Applicant: Mr J Stokes

Description: Conversion and extension of building to form apartments

Site Address: Caxton House Surgery, 53 High Street, Grimethorpe, Barnsley, S72 7BB.

A	Layout redesign	JS	14/12
Rev.	Description	By	Date
Project			
53 High Street			
Grimethorpe			
Barnsley			
S72 7BB			
Drawing Title			
Proposed Elevations			
Drawing No.	Rev.	Drawn by	Scale
high/04	A	J.S.	1:50@A1
		Date	Jul '22

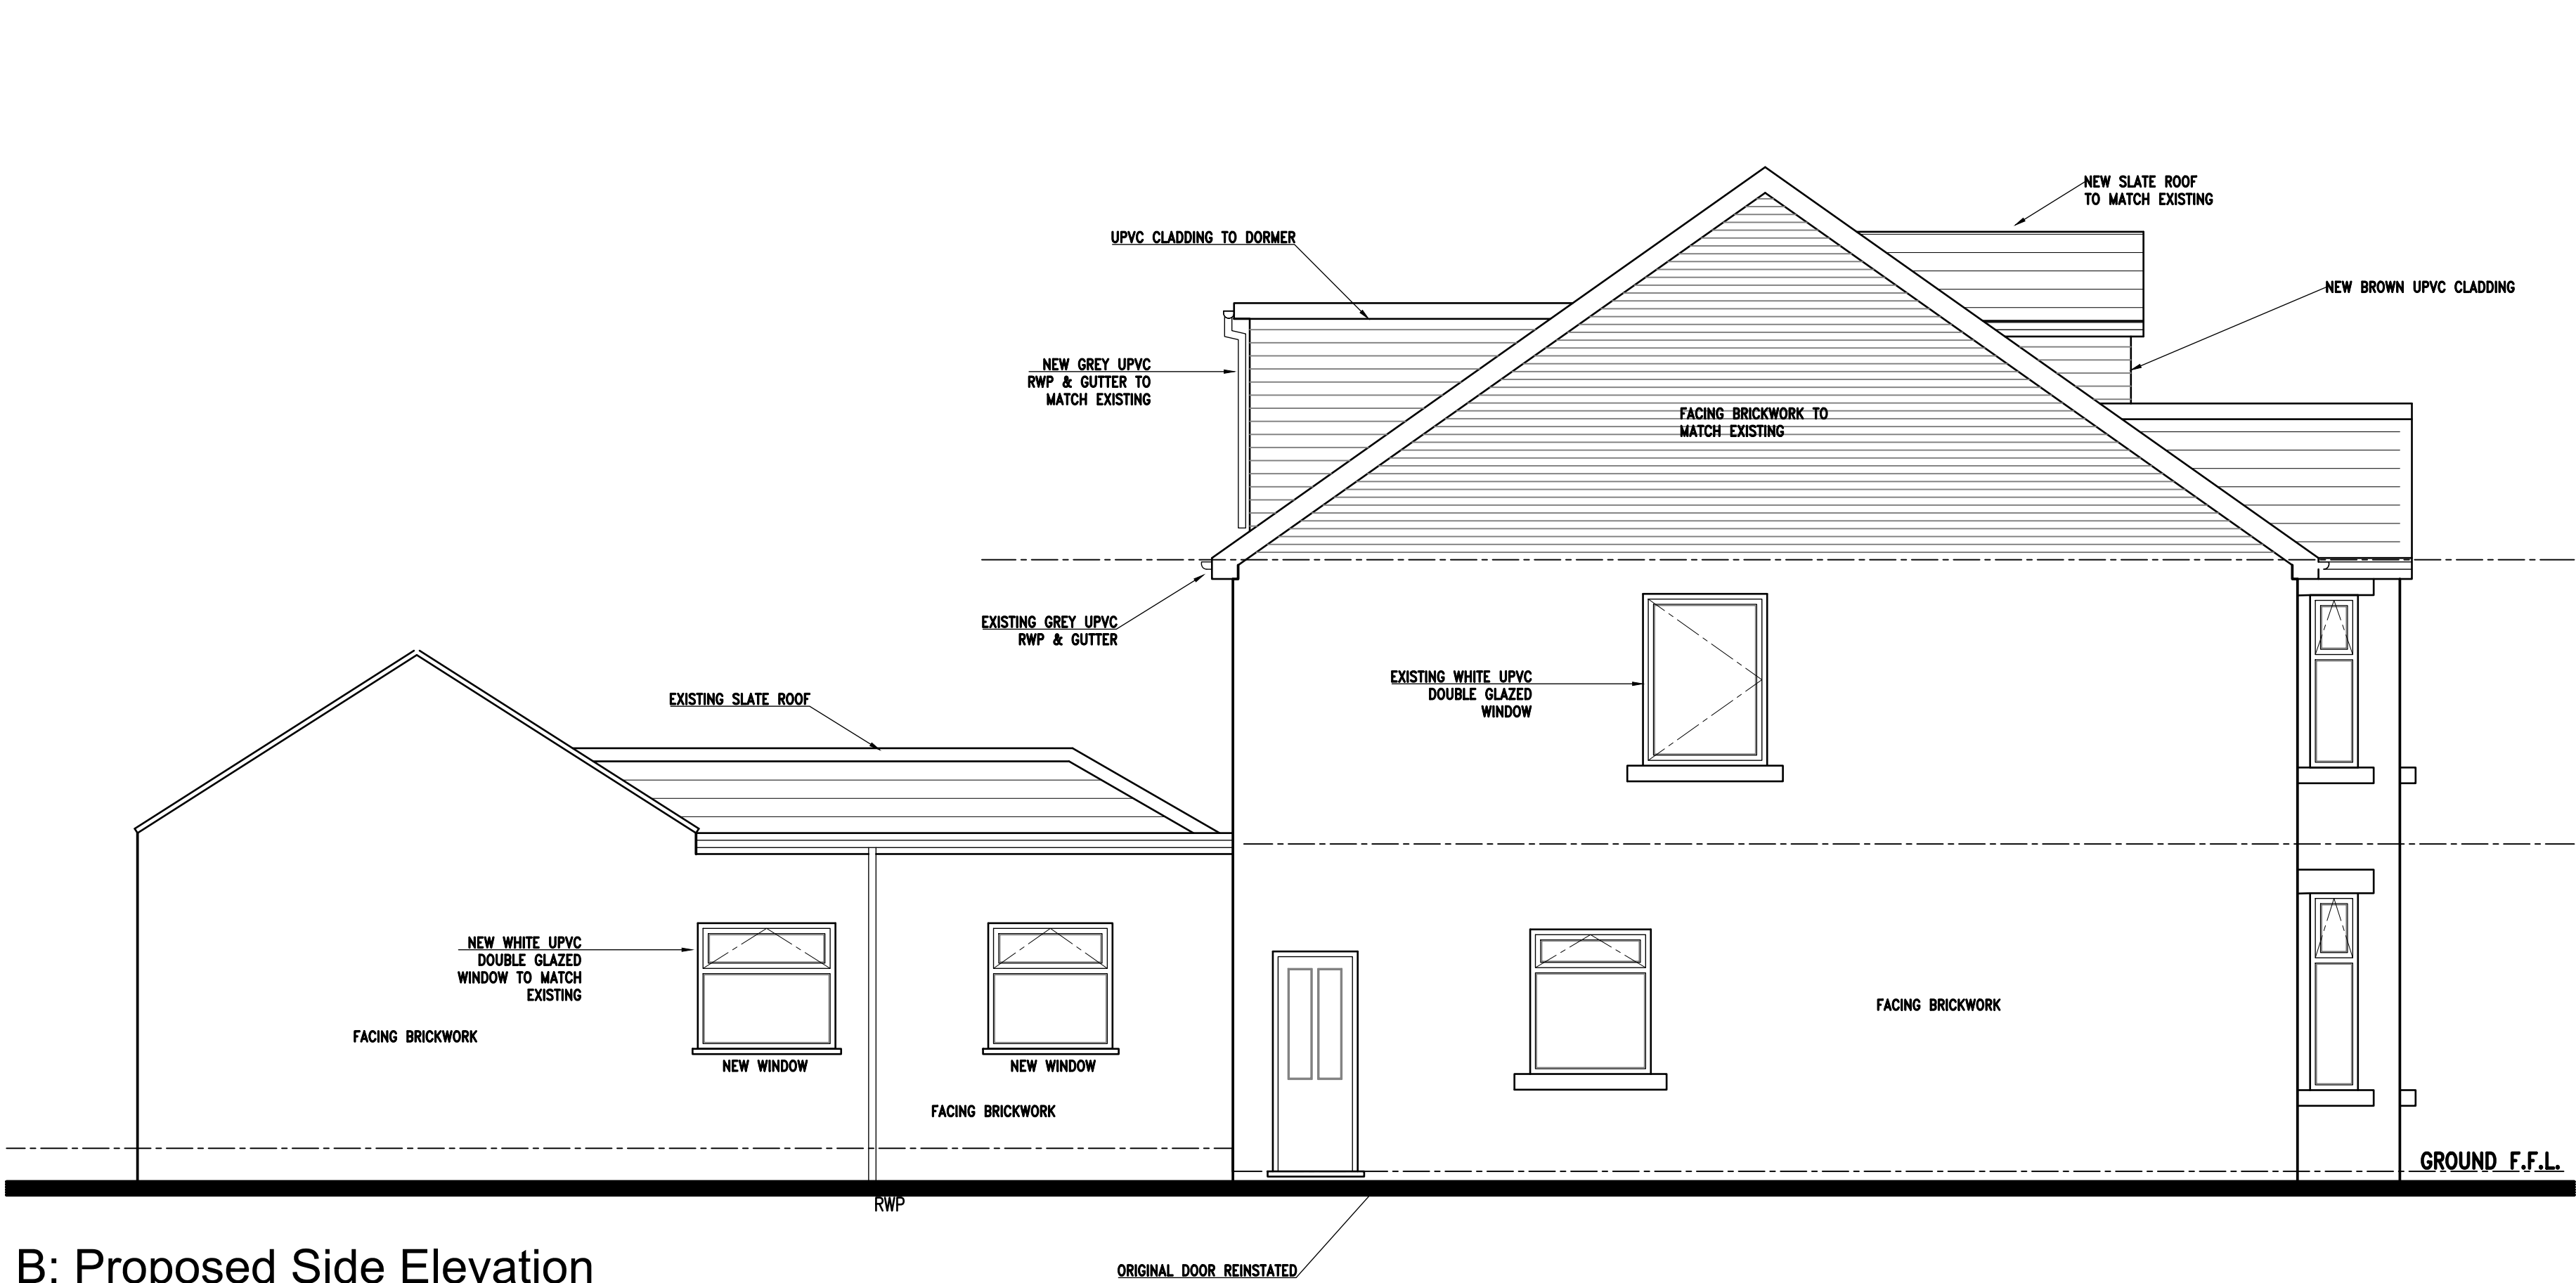
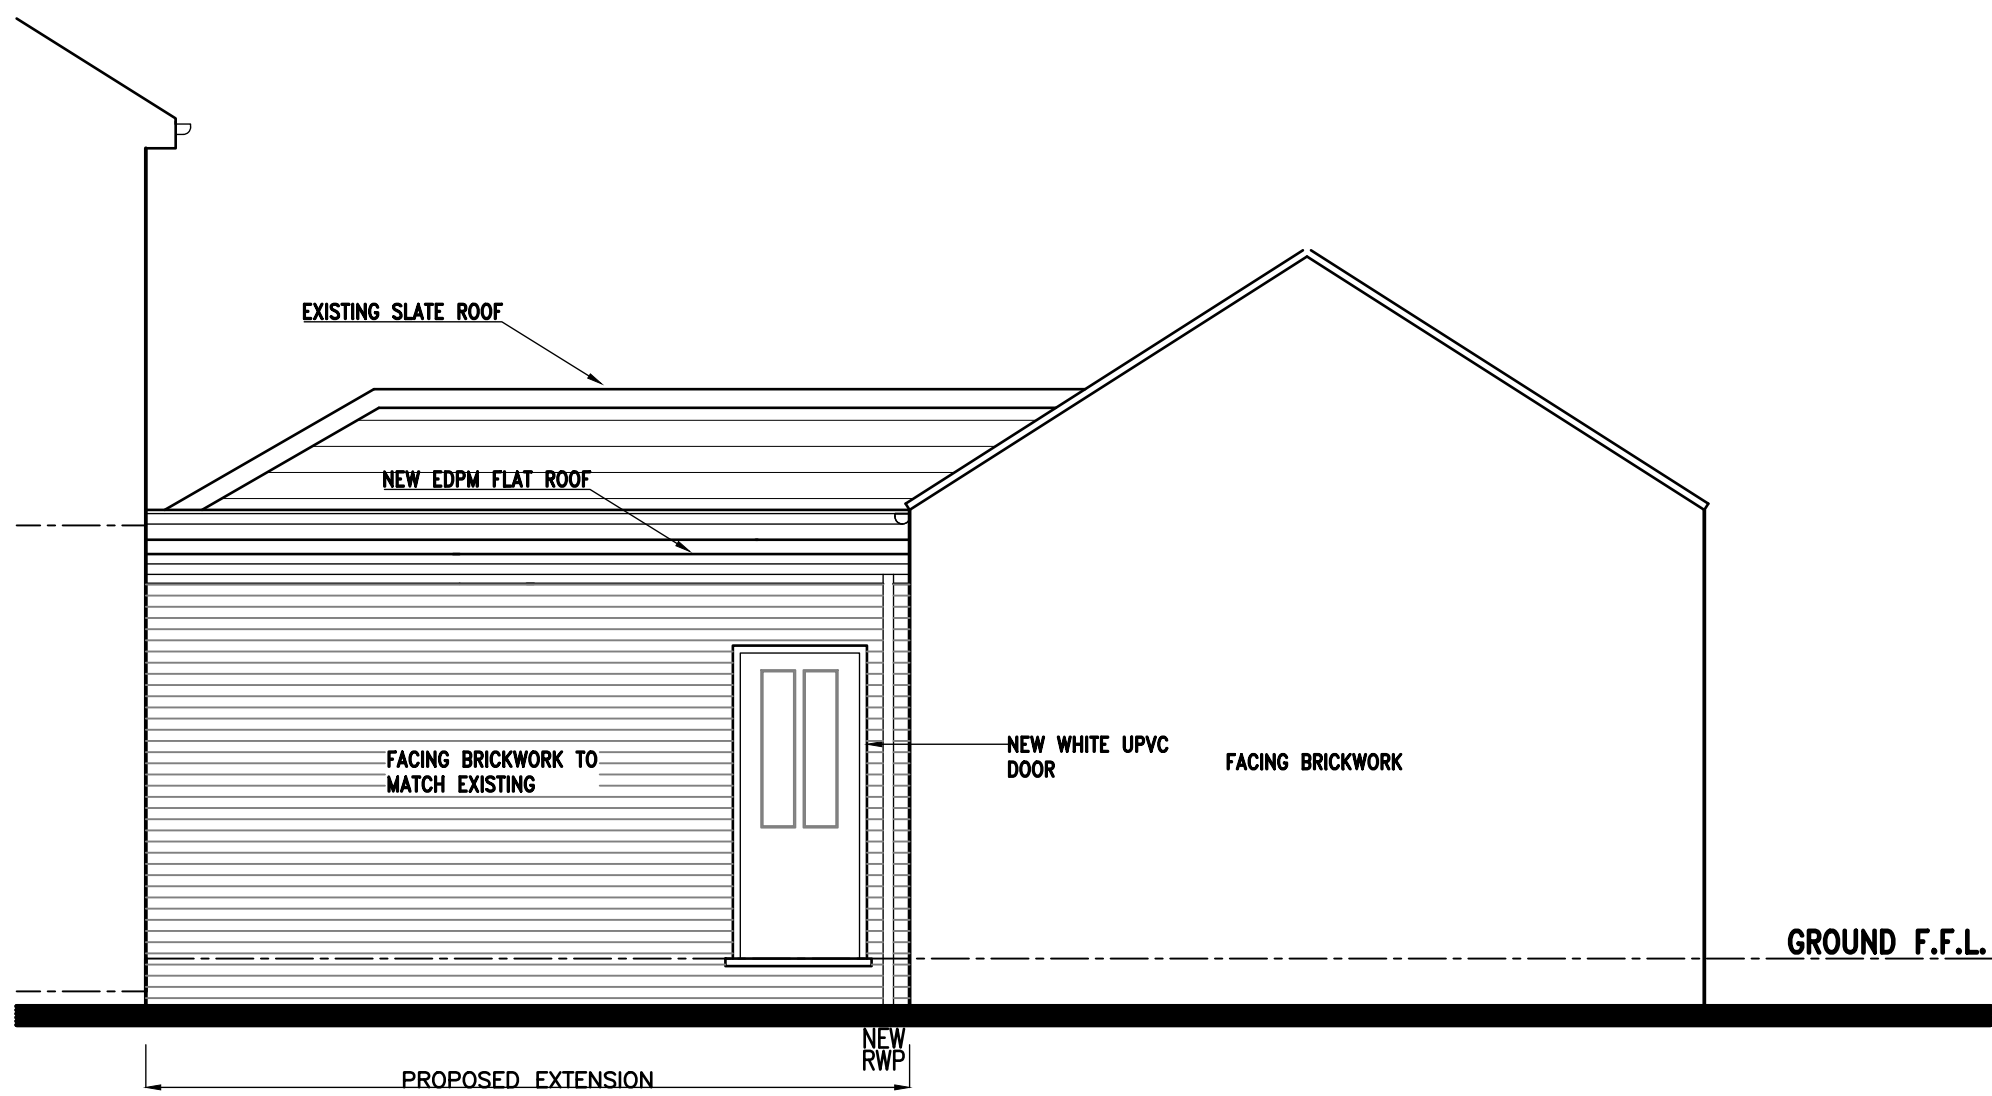
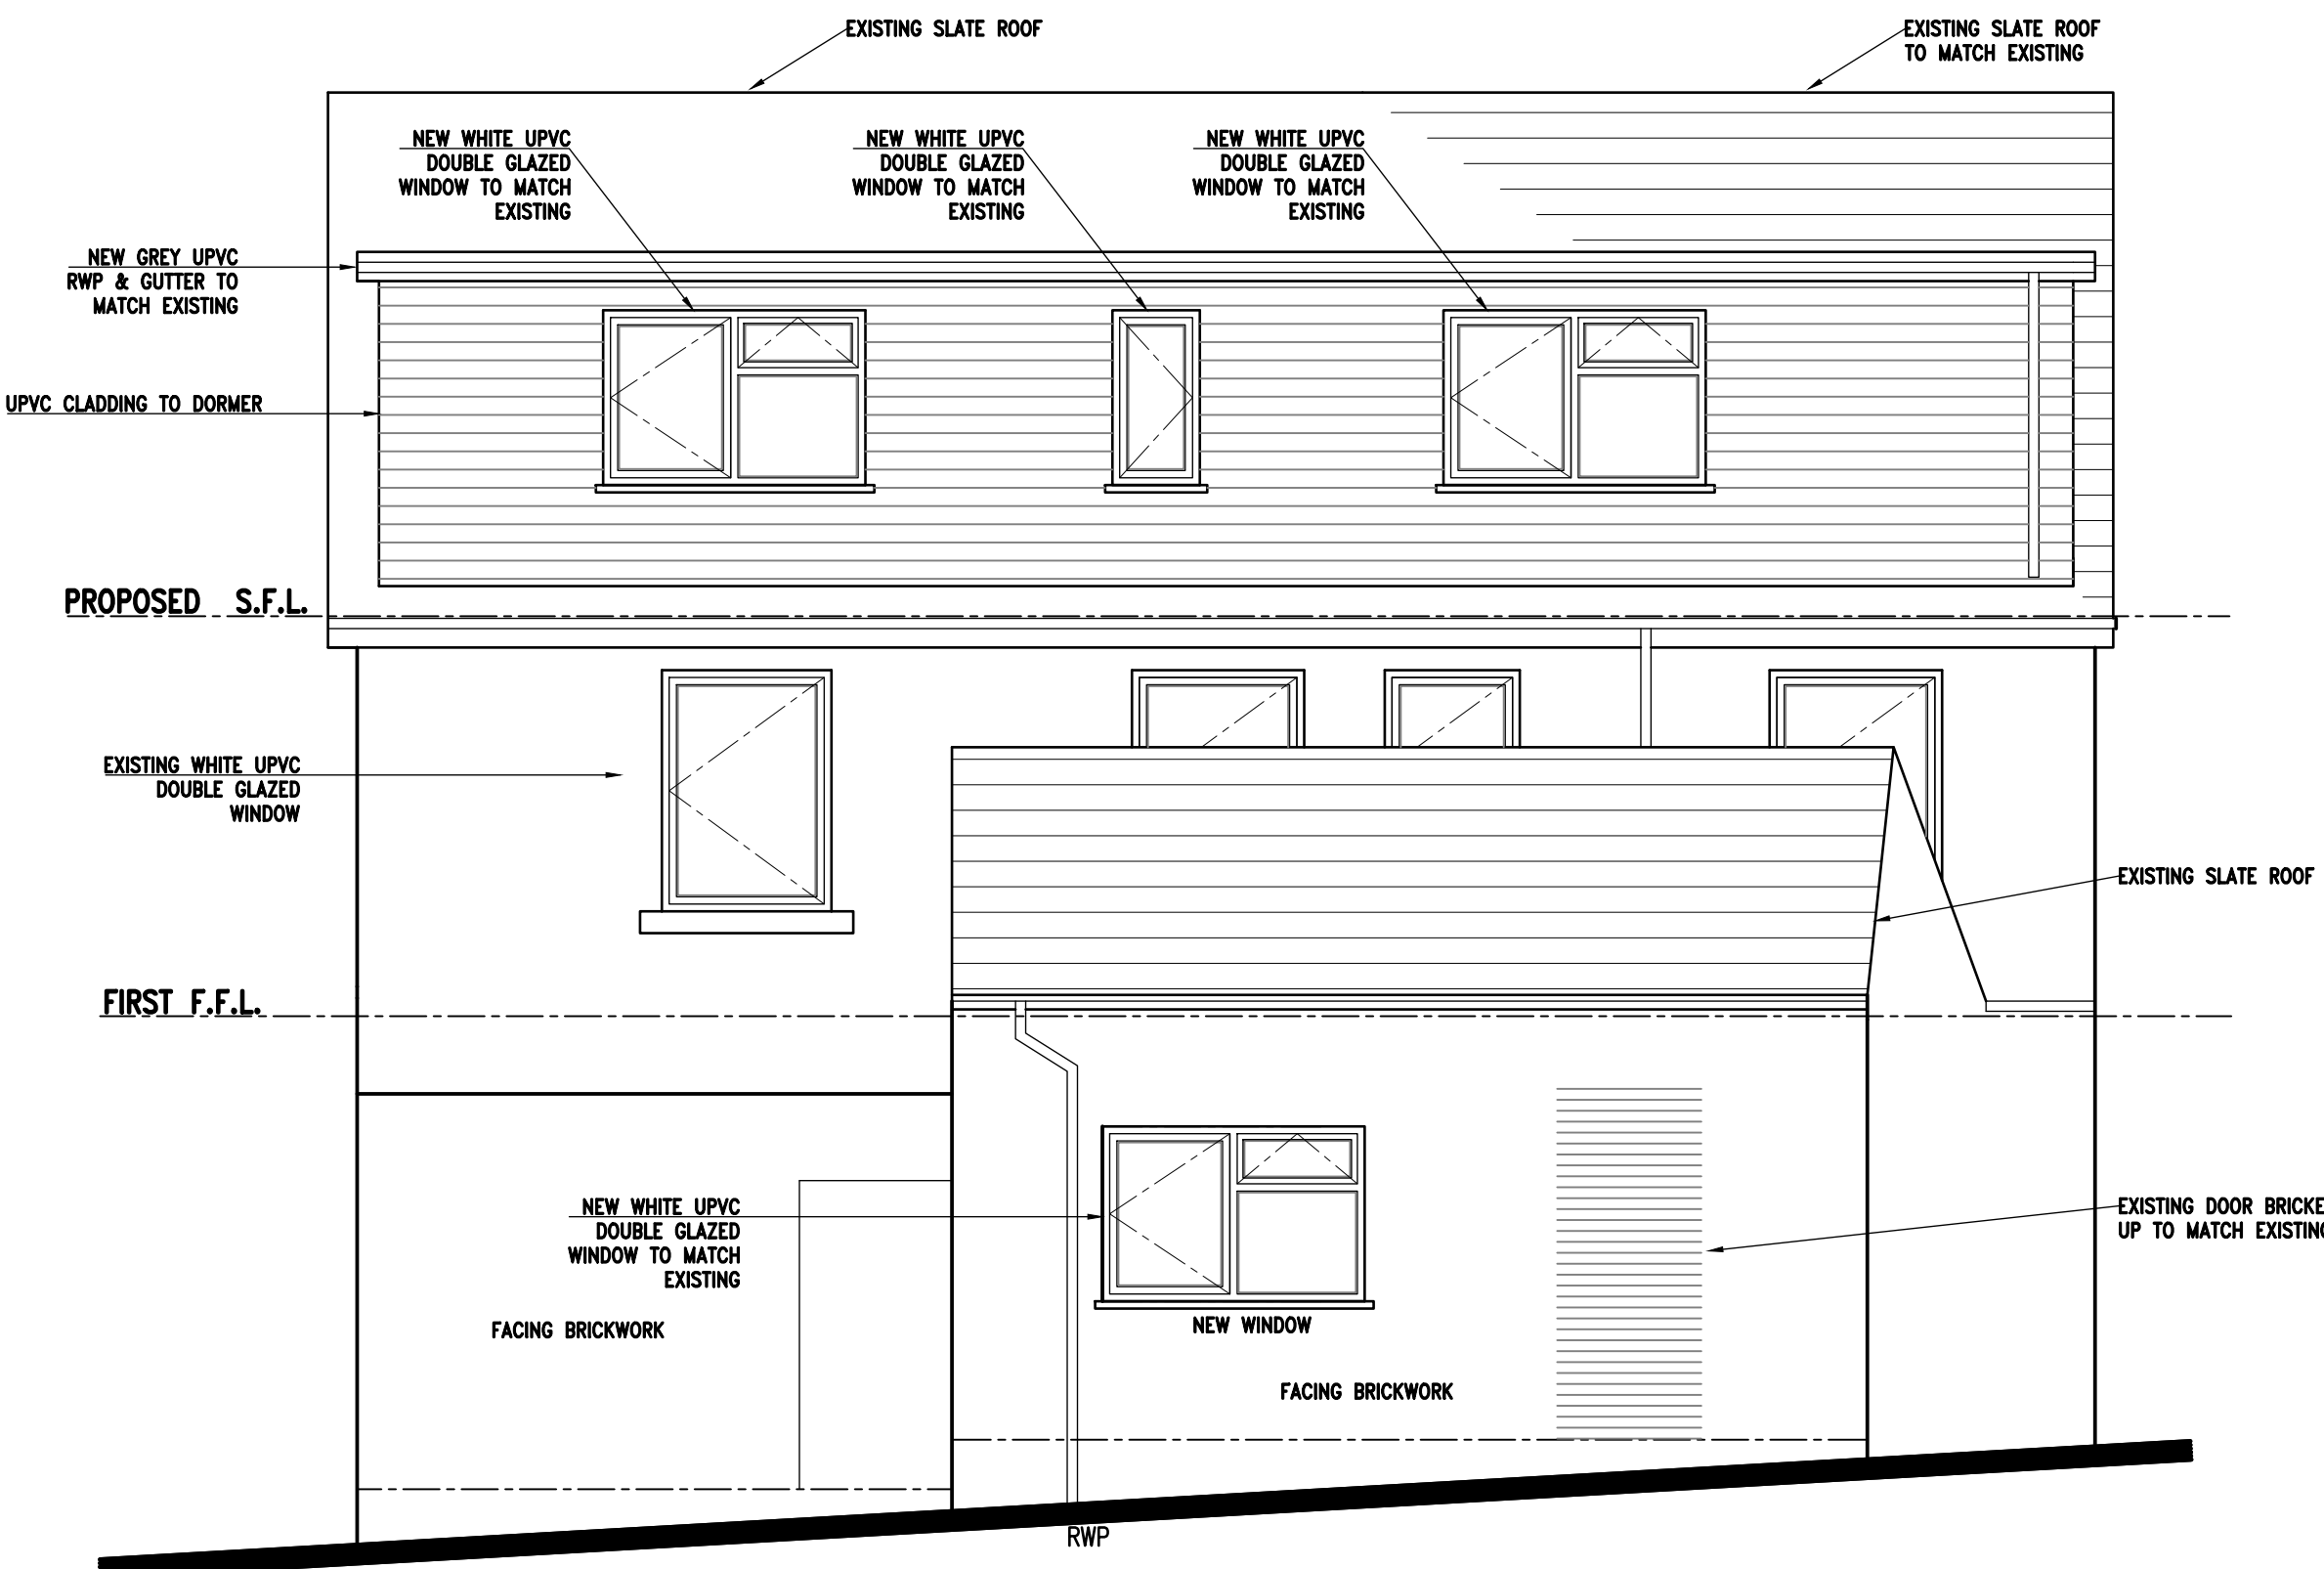
There are a number of external alterations proposed which include a hip to gable conversion, rooflights and smaller dormer windows to the front elevation, a flat roof rear dormer with 3no windows, removal of two existing chimney stacks, an original door re-instated to the side, a small infill extension, a bin store location, amenity space, new windows to the side and the bricking up of a number of windows and doors.

The conversion of the hipped roof to a gable would not increase the height of the roof and would be constructed from matching materials to the existing dwelling. There are existing properties within the immediate street scene with gable roof types and as such it is considered this alteration would be acceptable.

The SPD states that flat roof dormers are considered aesthetically inferior and are not normally acceptable and recommends guidelines which should be followed. The dormer is to the rear of the property and would not be highly visible from public vantage points. It is noted to the rear of the property there are existing garages and no residential properties. In terms of the guidelines the SPD specifies, the proposed dormer sits within the roof plane and the top of the dormer is below the ridge. The dormer is set back from the eaves by 0.46m which is a shortfall of 0.04m in what the guidance specifies and is set in from the adjacent property by 0.28m which is a shortfall of 0.22m. Although there is a small shortfall it is not considered detrimental considering the dormer has been set down and in, would not be highly visible and would again be constructed from matching materials to the existing dwelling.

The revised scheme has introduced small dormers to the front elevation of the building. The dormers are pitched, alike the proposed roof which would be acceptable in terms of design. The House Extensions and Other Domestic Alterations SPD states that as to not dominate the existing roof lines and retain its original form, dormers should be set within the roof plane and not be built off an external wall. Further, the former should sit within the roof plane and the top of the dormer should usually be below the ridge, the dormer should be set back from the eaves and gable by at least 0.5m and should also be 0.5m from the party walls with adjacent properties. The front dormers would meet this standard and are acceptable.

All habitable room windows are served by windows which would provide a good outlook and amount of light into the apartments. The windows serving the bedrooms of apartment five and six are smaller than the other windows however this is a betterment over the rooflights over the previously refused application and the proposed elevations show that the windows will open allowing for daylight.
